File Ref: SSD-10468

New Request for Advice – Warehouse and Customer Fulfilment Centre, Marrickville

Property: 74 Edinburgh Road, Marrickville

Council has reviewed the submitted additional information forming the formal Response to Submissions and makes the following comments:

Drawing Name:
Landscape Plan
Ground Floor

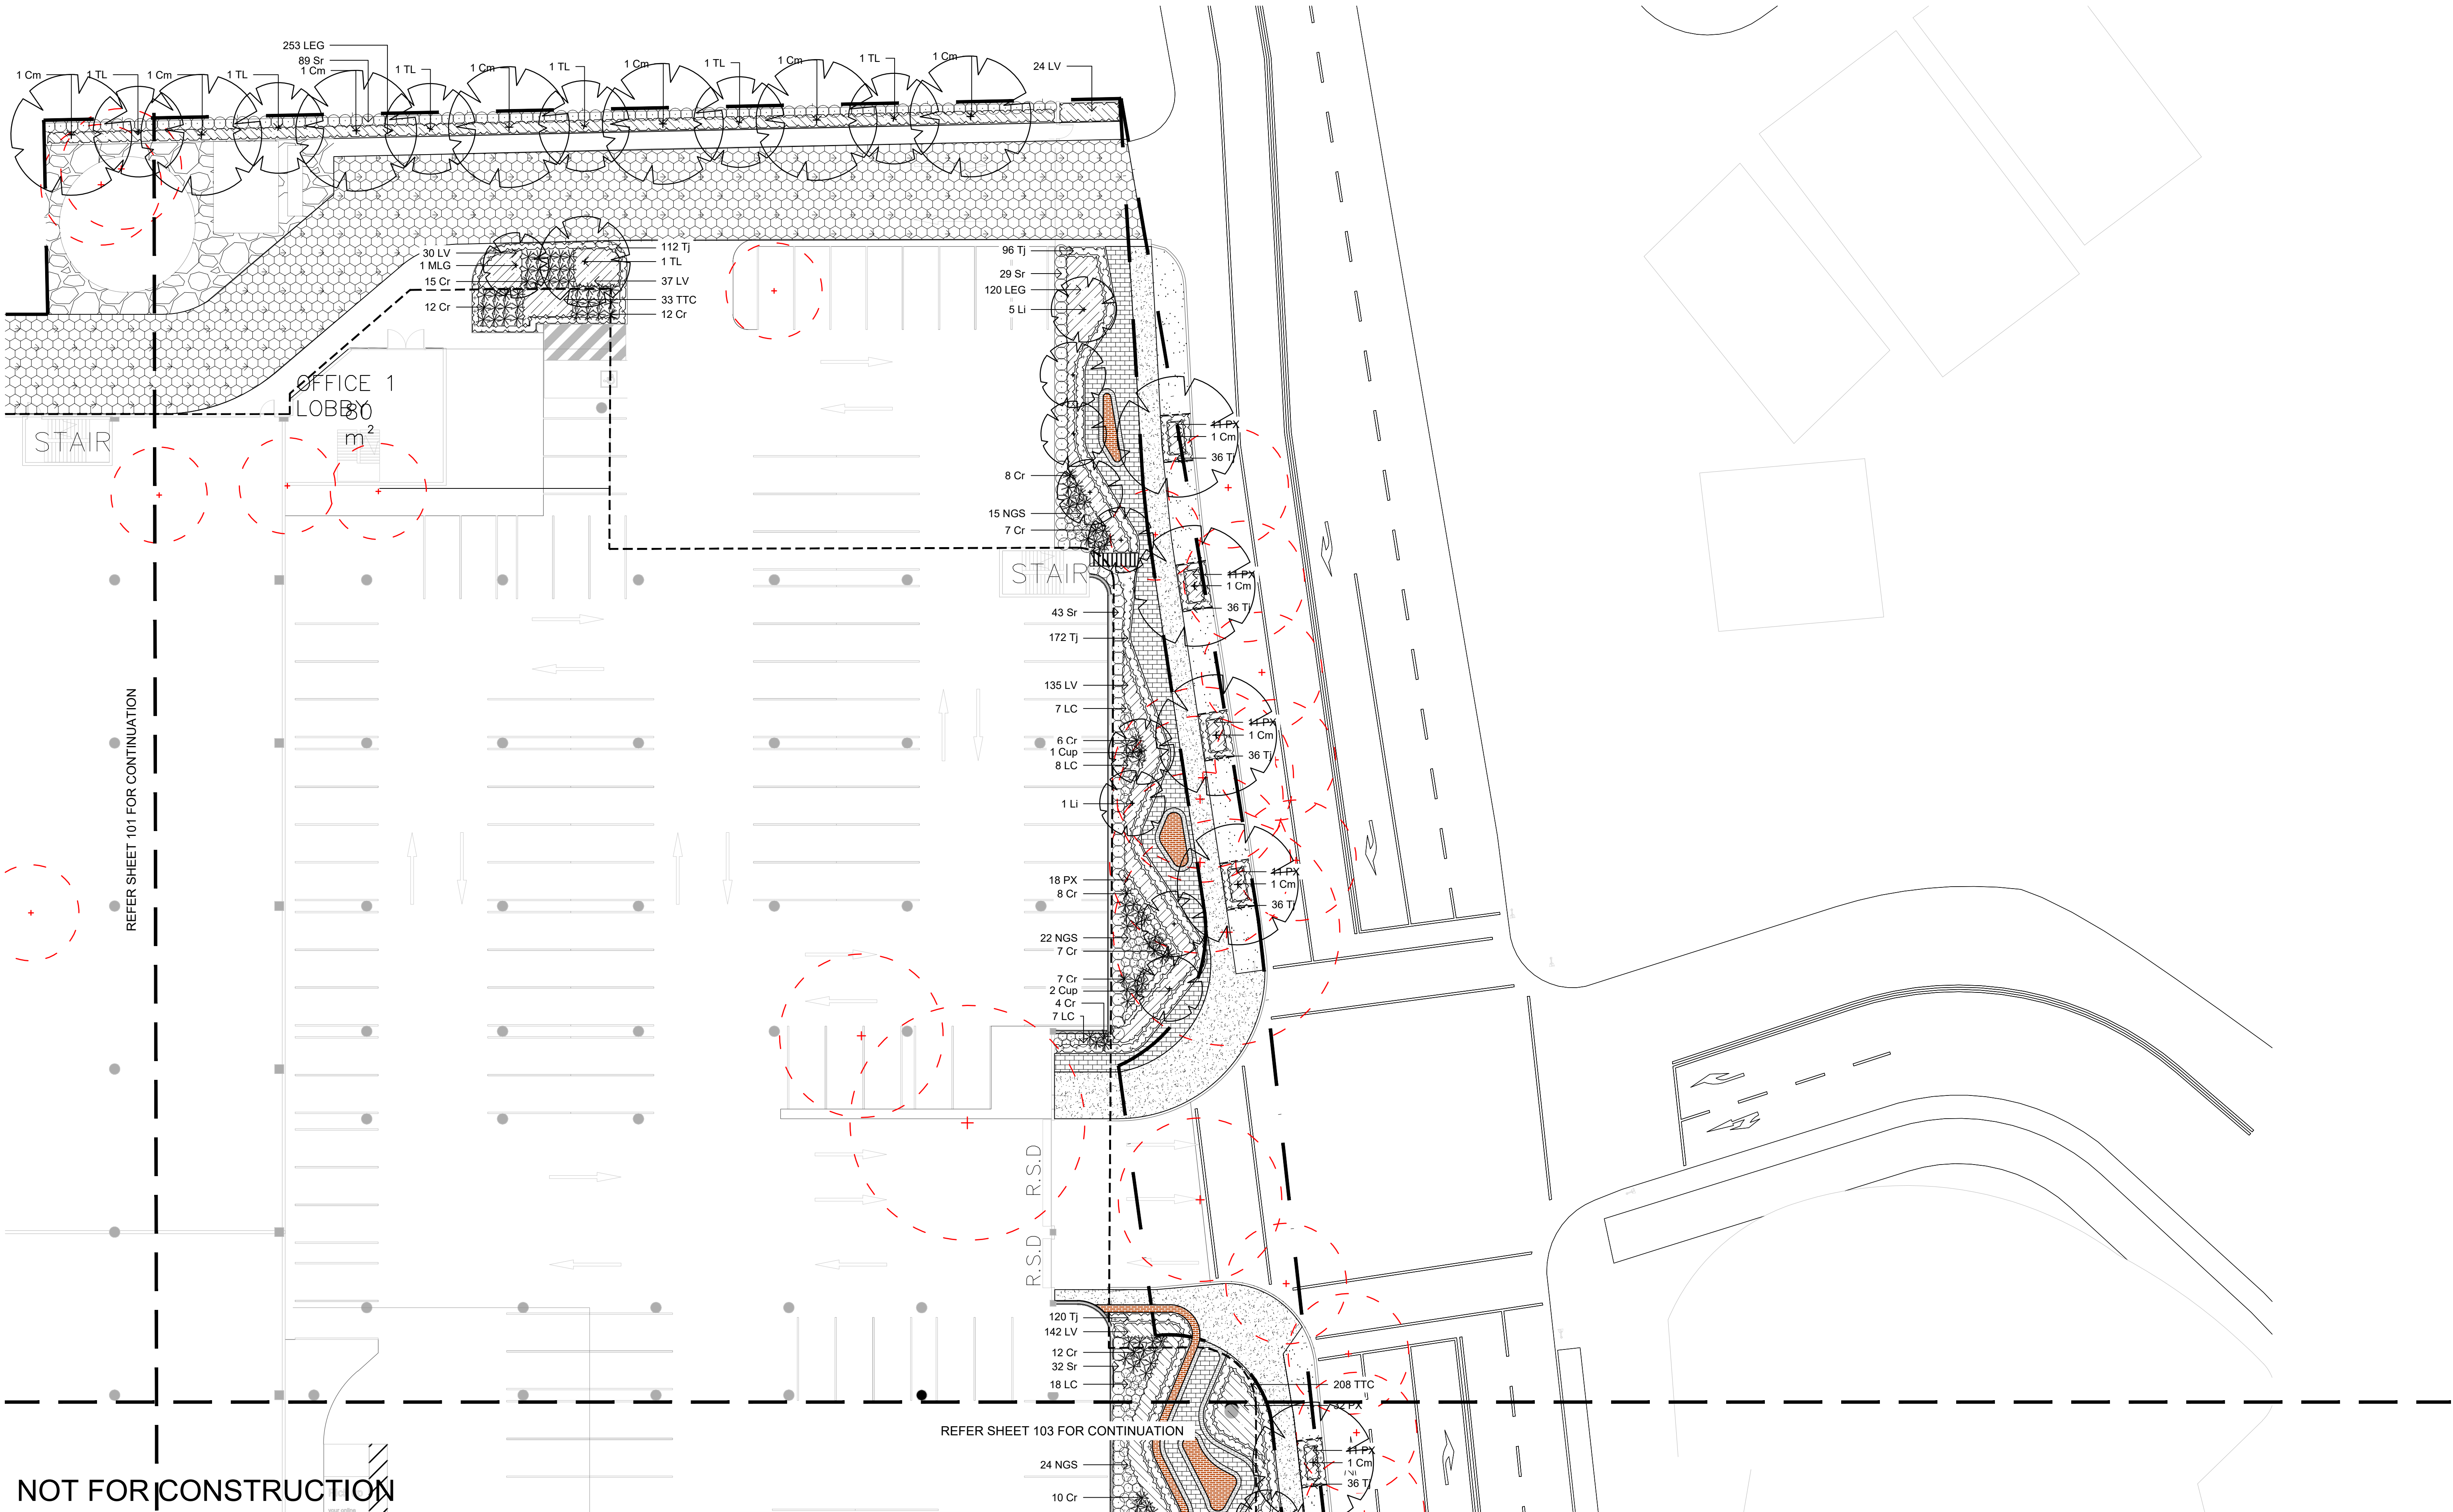
- v. There is not sufficient detail on the plans to determine if Tree 74 can be viably retained (even with Arborist supervision and tree sensitive methods as recommended). Any proposal that will impact the structural stability or health of a tree on an adjacent site, will require the neighbouring owners consent for removal. It is recommended that the viability of Tree 74 be investigated in detail before any further design development so that adjustment can be made if required. Proposed trees - Where new trees are proposed within or adjacent to large areas of pavement it is recommended that Strata Vault or similar are installed to provide sufficient non compacted below pavement soil volumes for viable and long term tree growth. It is recommended that Final Landscape Plans include soil volume calculations for each tree.

- vi. Proposed trees - Where new trees are proposed within or adjacent to large areas of pavement it is recommended that Strata Vault or similar are installed to provide sufficient non compacted below pavement soil volumes for viable and long term tree growth. It is recommended that Final Landscape Plans include soil volume calculations for each tree.

- vii. Relocation of stormwater culvert – The proposed location of the culvert is not supported because of the direct impact this will have on soil volumes available for the replacement streets on Edinburgh Road and internal landscape trees along this street frontage. The culvert location must be amended so that required deep soil volumes for trees are not constrained. The removal of the existing trees cannot be supported unless the trees are to be replaced in a viable growing environment.

- viii. Soil volumes for trees – The Landscape Plans/Landscape Report must include soil volume calculations demonstrating that street trees and site trees have sufficient soil volumes to allow for the development of healthy root systems. Note – Medium trees ideally require approx. 27-38 m³ and large trees approx. 27-39 m³ (each) depending on soil conditions. Where trees are planted in shared contiguous planting zones and irrigated the soil volumes may be able to be reduced.

Figure 34 Post Development 1% AEP Flood Velocity (m/s)

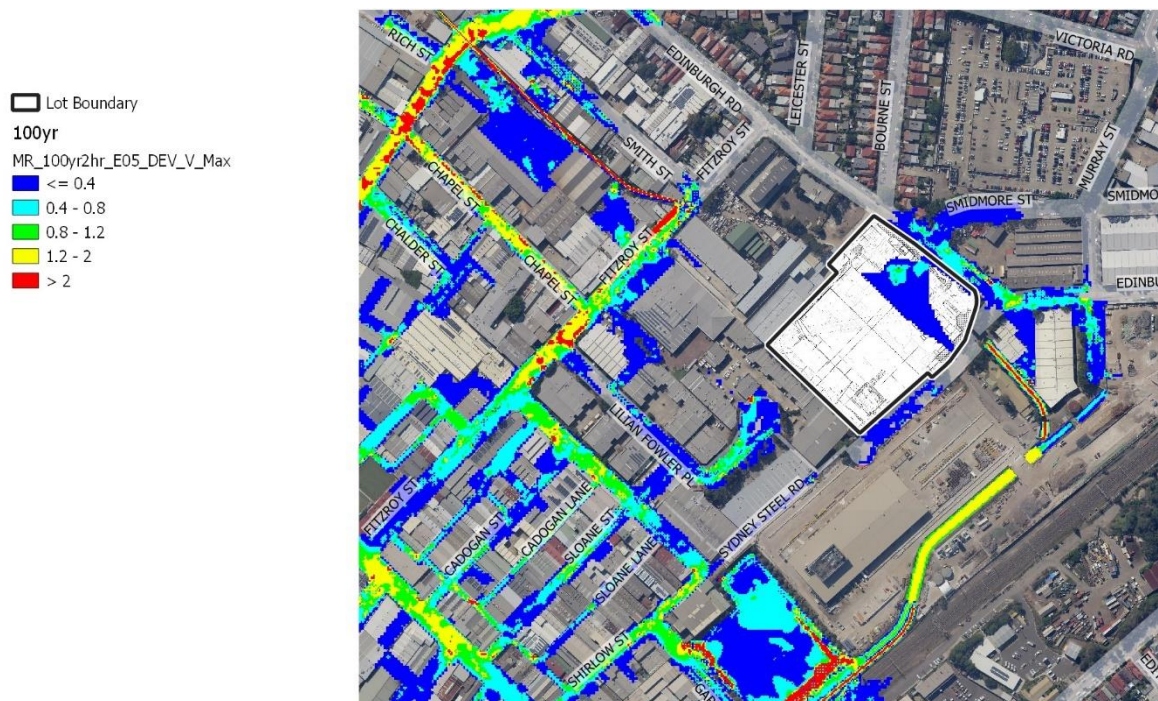
- i. The amended proposal has reduced the 1 in 100 year flood level applicable to the site from 4.81m to 4.61m AHD (200mm) with no explanation on how this was achieved given that no additional flood storage was proposed. Further clarification on how this was achieved will need to be provided. Given the extent of flooding on the site and the impacts that may occur off site it recommended the flood model be peer reviewed by an independent consultant such as GRC Hydro who has done a lot of work for the Sydney Metro project in the area and has good knowledge of the drainage system.

- iii. As previously advised the improvement post development in flood depths is achieved by collecting the flood waters by pit inlets and diverting them to an underground flood detention of 1200m³ volume equal to the existing site's above ground 1% AEP flood storage. The current stormwater plans detail very little inlet capacity to adequately capture these overland flows arriving on the site. It appears the inlet capacity is only provided by a single 2.4m kerb inlet pit (Pit 4A) and a single 900x900 grated pit (Pit 4B) which is unsatisfactory.
